**RE: - PROPOSED EXTENSIONS AT ARBOUR FARM
CHIPPING ROAD, THORNLEY, PRESTON PR3 2TE**

NOTES EMAIL 8 NOVEMBER 2017 FROM RVBC

RE: MR D FARRADY - DOMESTIC EXTENSION AT ARBOUR COTTAGE
THORNLEY

**Drawing Title**  
 EXISTING & PROPOSED ELEVATIONS & PLAN LAYOUT

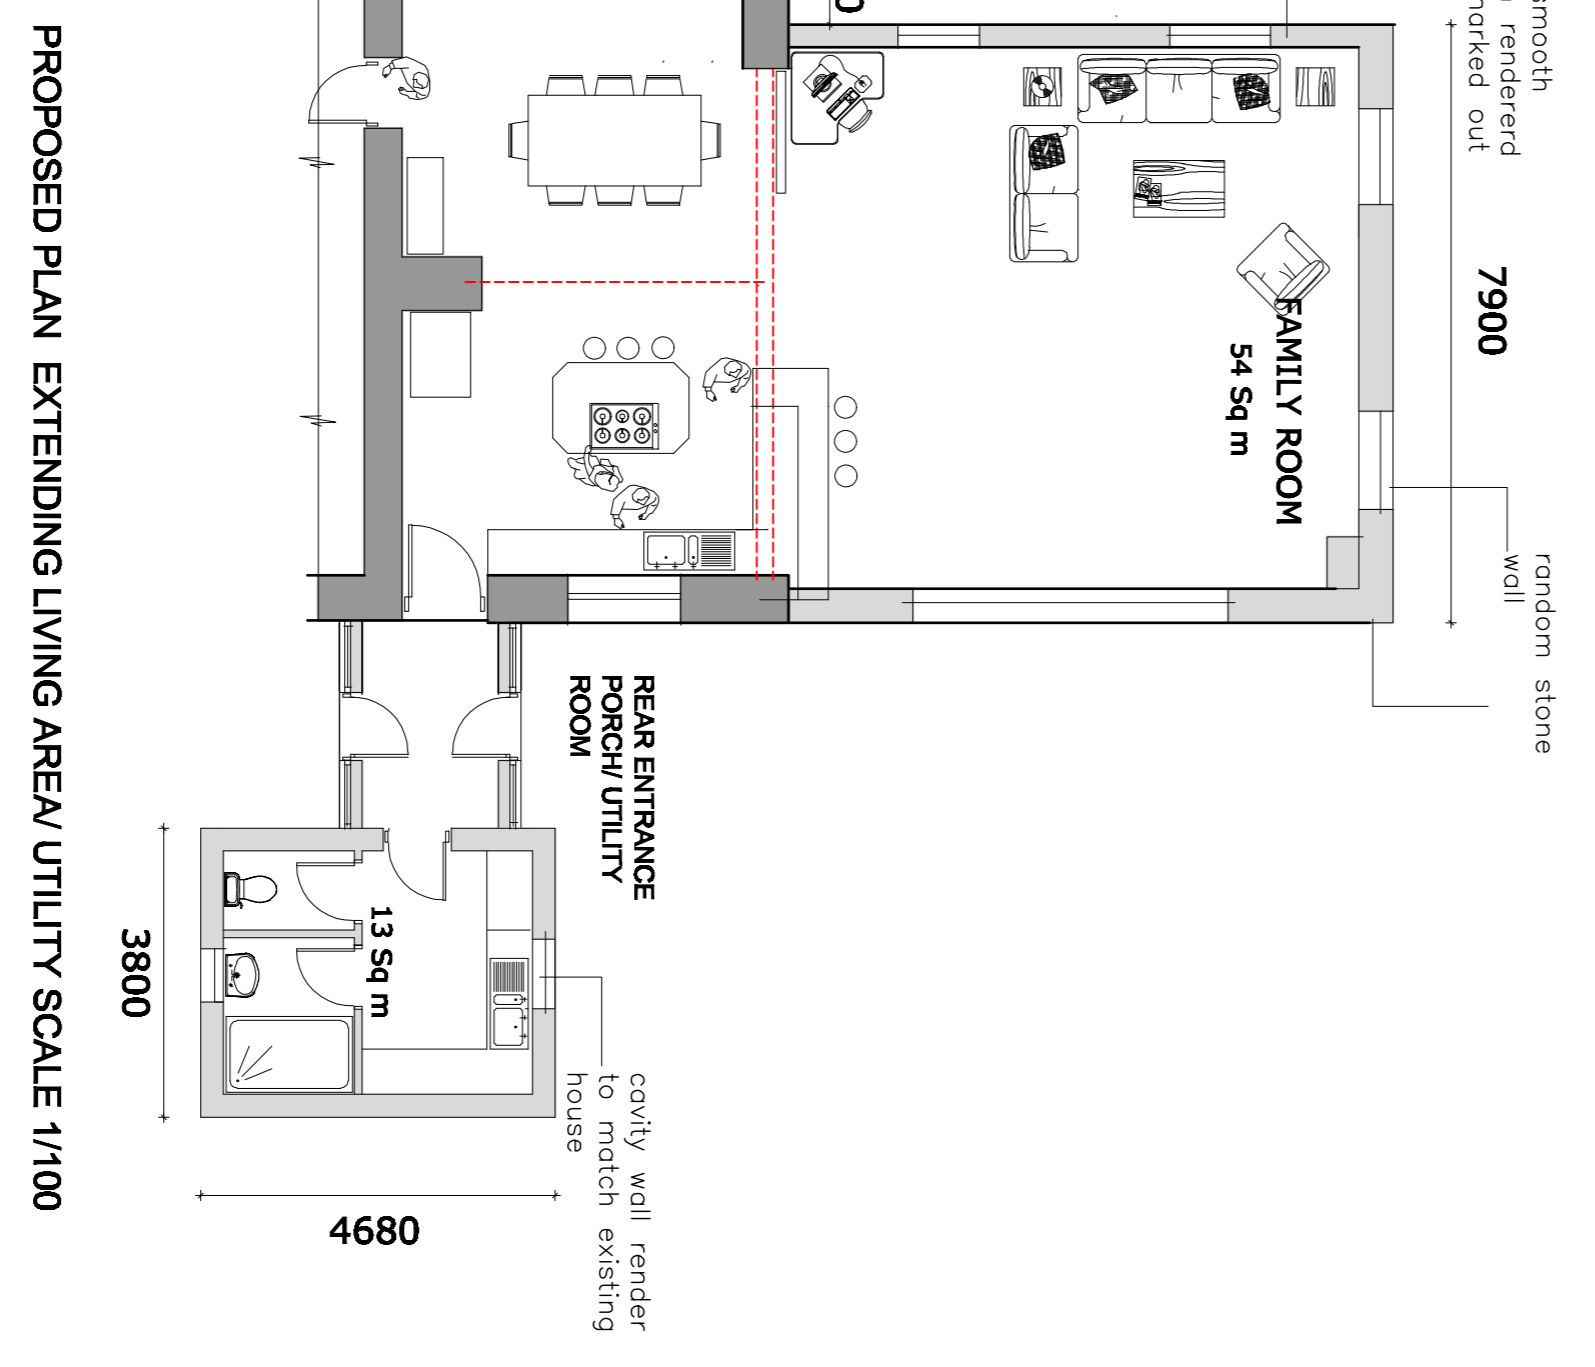
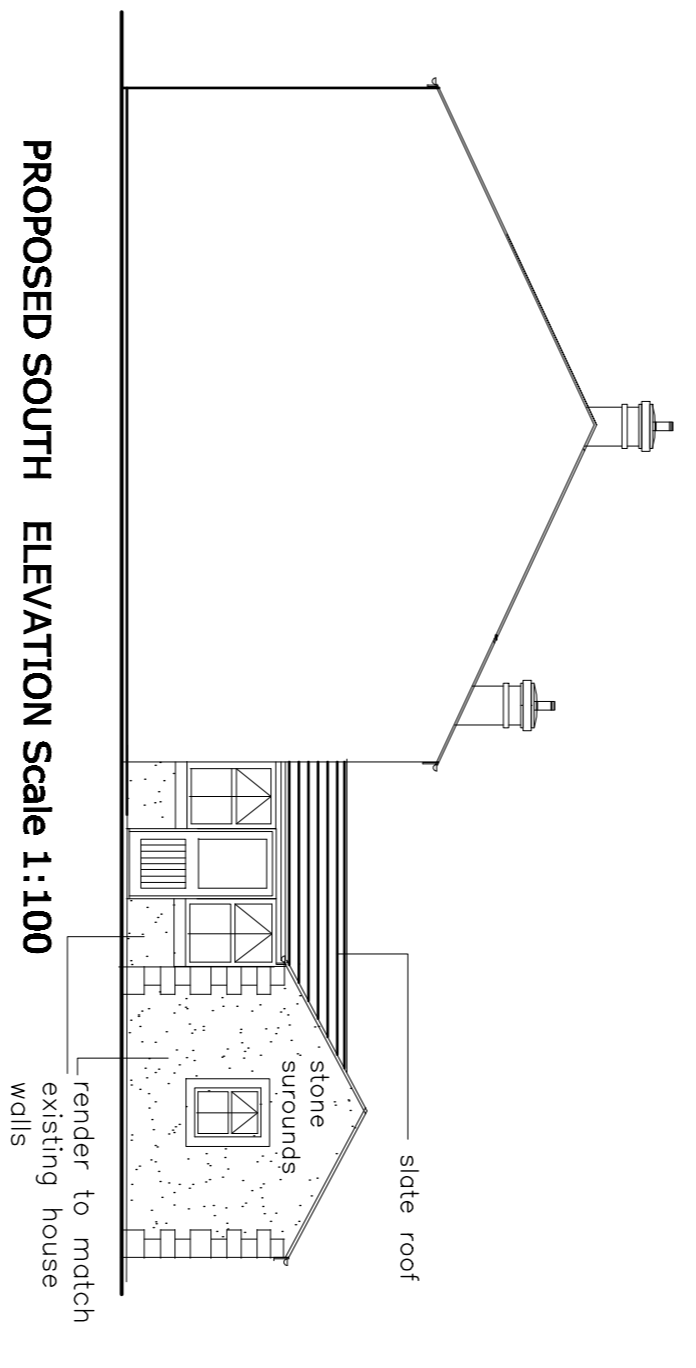
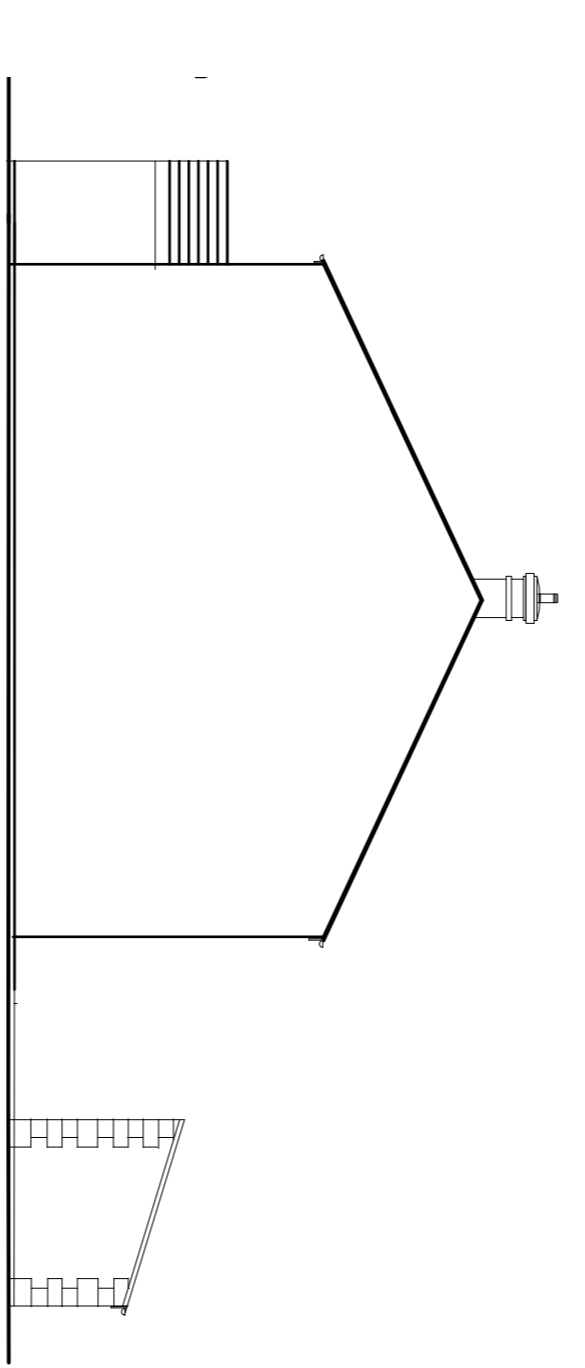
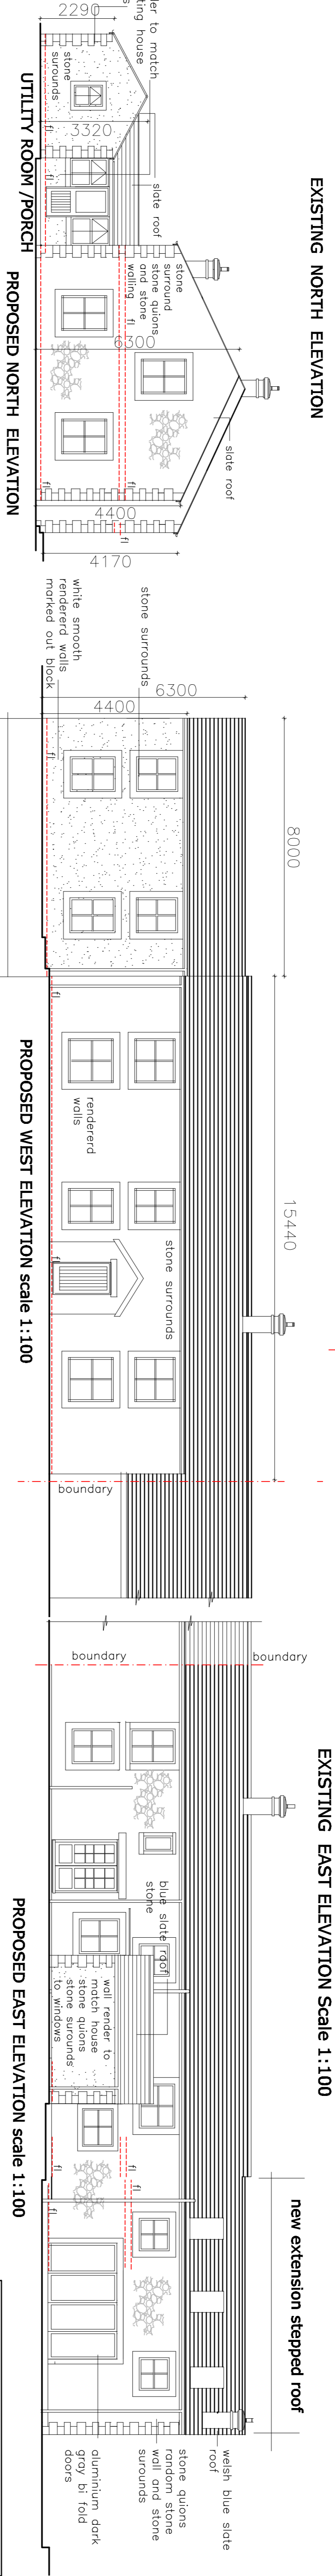
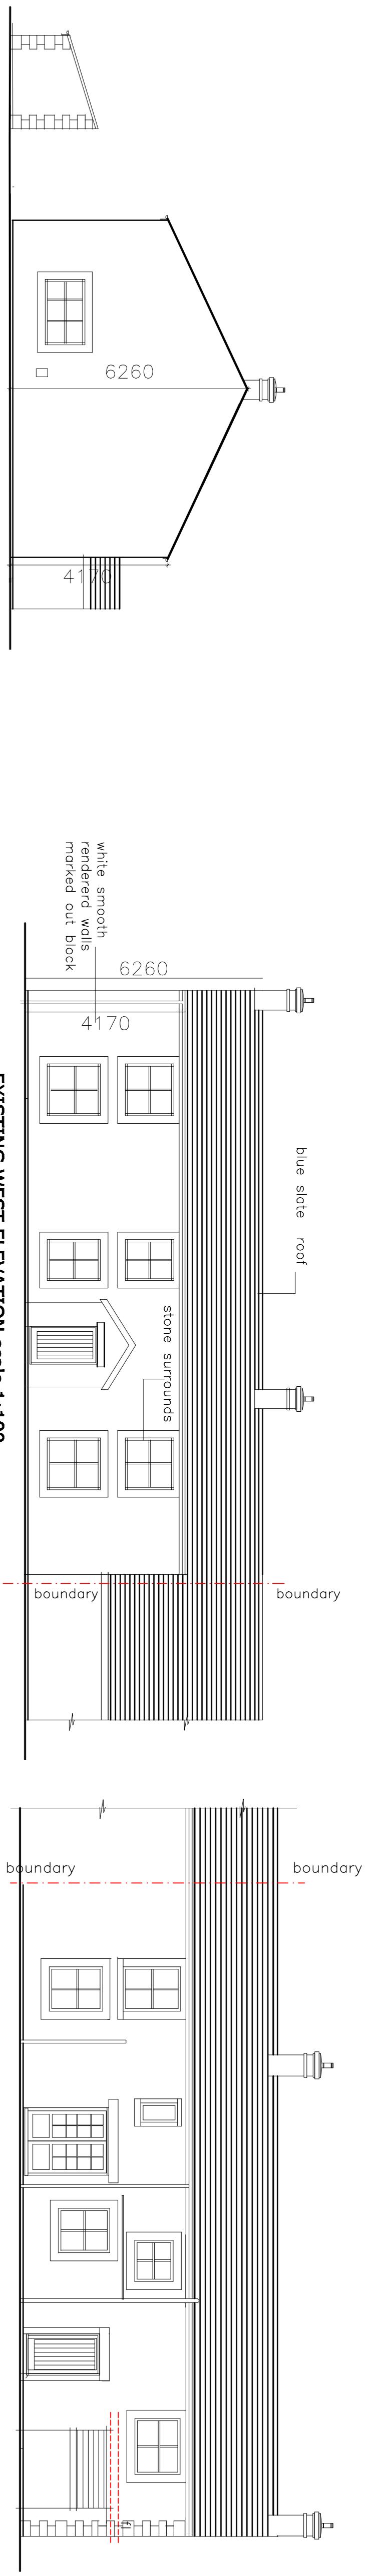
In my opinion, the introduction of a cat-slide roof as proposed for option 2 and 3 would in my opinion result in a disproportionately sized northern gable elevation harmful to the appearance of the dwelling and rural locality contrary to DMG1 and EN2 of the Core Strategy.

I consider that Option 1 is the most appropriate in scale and massing. As highlighted at our meeting I do have concern with regards to the introduction of a 'juliet balcony' to the northern elevation at first floor as in my opinion this would detract from the rural character of the property. I would therefore advise that this feature is removed and replaced with a window. Furthermore, whilst I note that the windows to the front (western) elevation of the existing main farmhouse differ in size, I am of the opinion that adding this feature to the proposed extension will appear somewhat odd. I consider that there should be a clear distinction between the proposed extension and the main farmhouse. Therefore I would advise that the windows to the northern end of the proposed extension to the western elevation should be reduced to match those to the south-western end of the extension. For clarity I have attached a sketch.

Therefore in my opinion subject to the amendments as advised above being incorporated into the plans for the proposed scheme I consider that the development would be acceptable in principle.
